CS243

LOCATION, ACREAGE, PARCEL ID INFO, & ZONING

REQUEST

JUSTIFICATION (**Sec. 5.3.5.B Map Amendment (Rezoning)**)

Key Areas

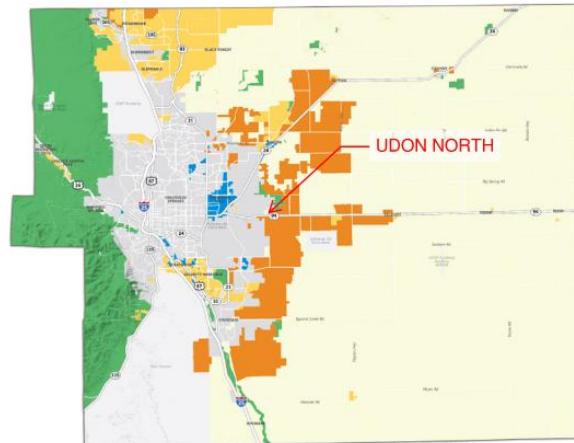
Explain how the proposal is consistent with the Key Area.

Natural or Physical Site Features:

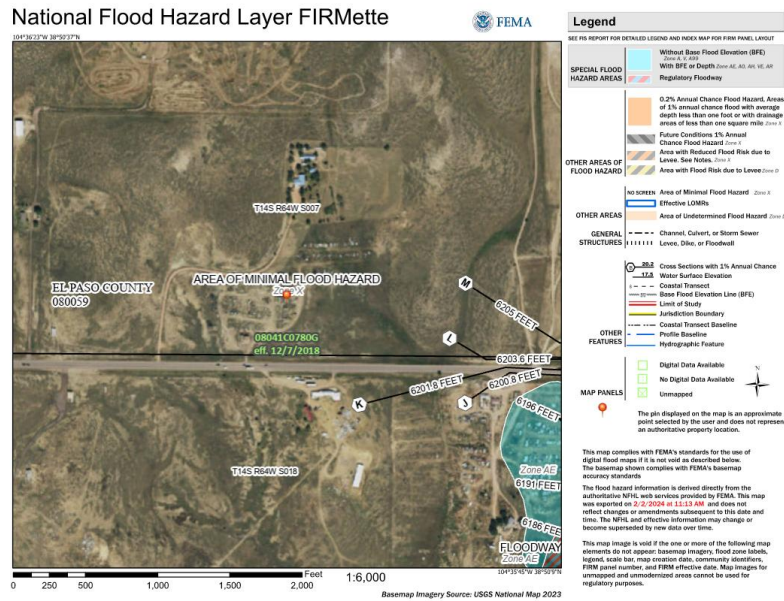
How is a rezone to a far more intense zoning district going to preserve the natural features? The next sentence conflicts with this statement as well by stating there are no natural features.

C. Wildlife Considerations:

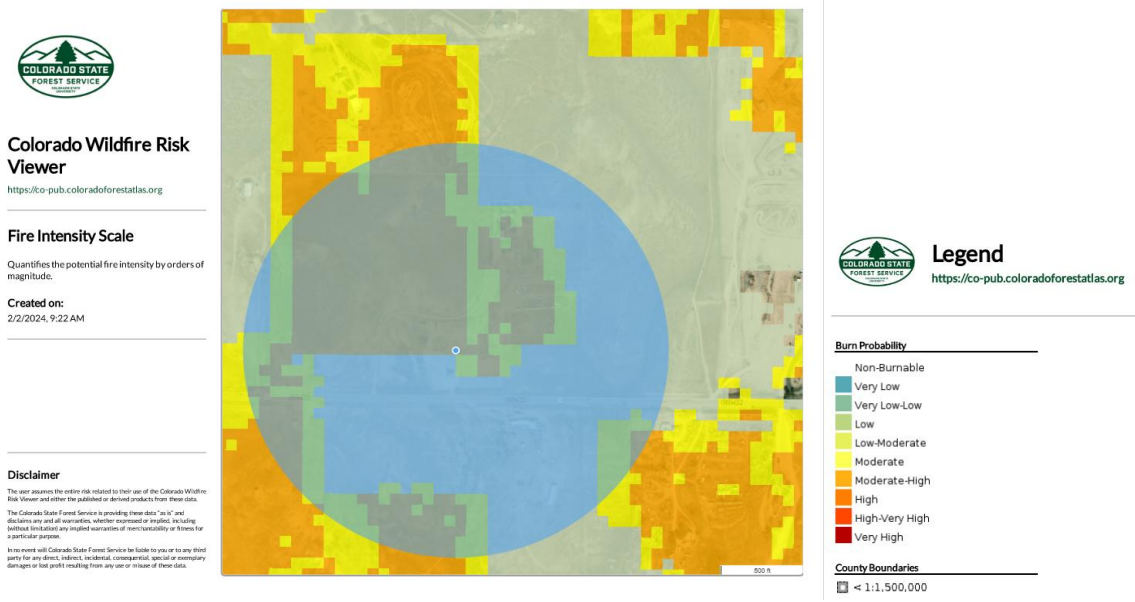
Wildlife or wildfire?

These two statements appear to conflict with each other.

FIGURE 20
 UDON REZONE
 EL PASO COUNTY, COLORADO
 2045 RECOMMENDED GEOMETRY &
 CONTROL – PROPOSED BUILDOUT

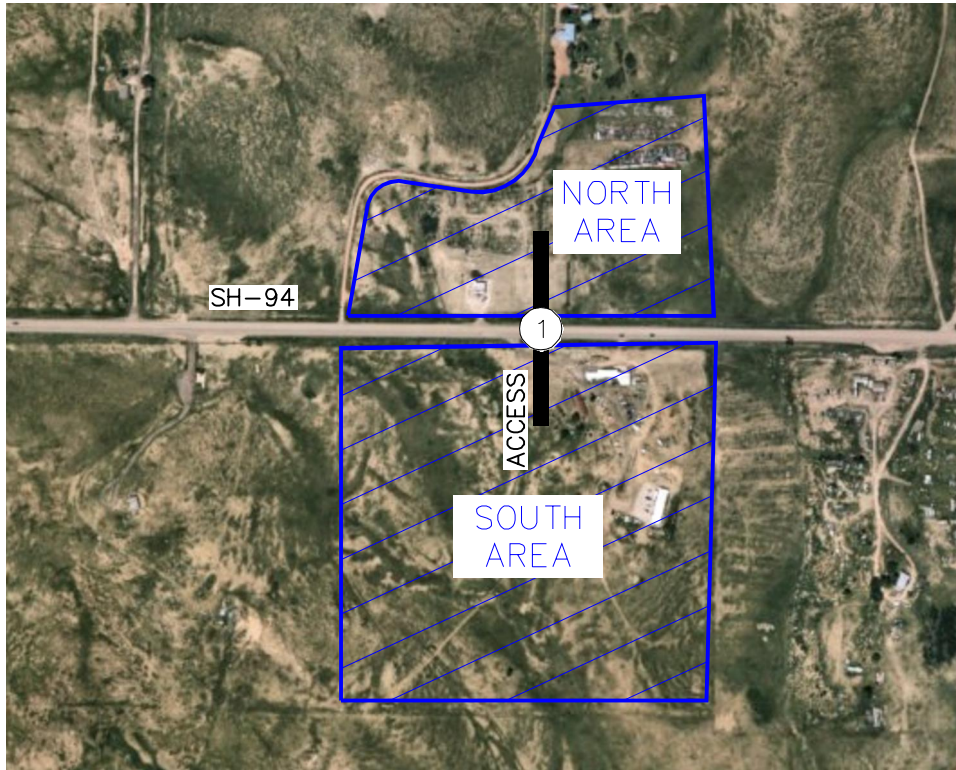
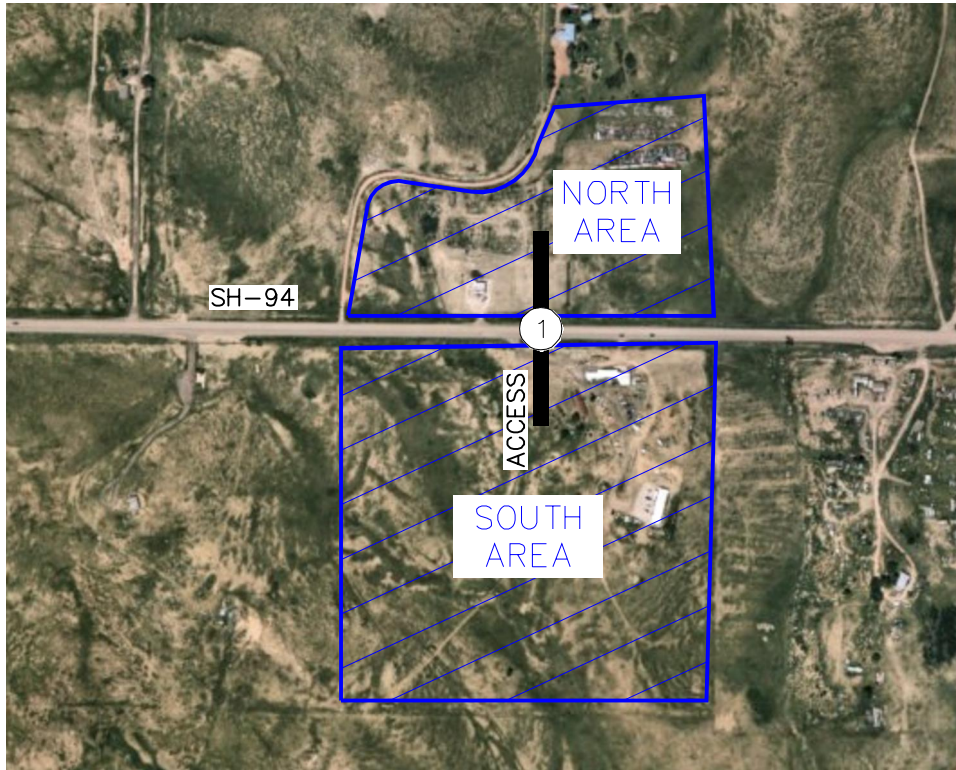
This doesn't seem to match TIS pg 4 or the table extract below which notes South area developing first as part of phase 1. Please clarify what is being proposed with this specific rezoning in the north area.
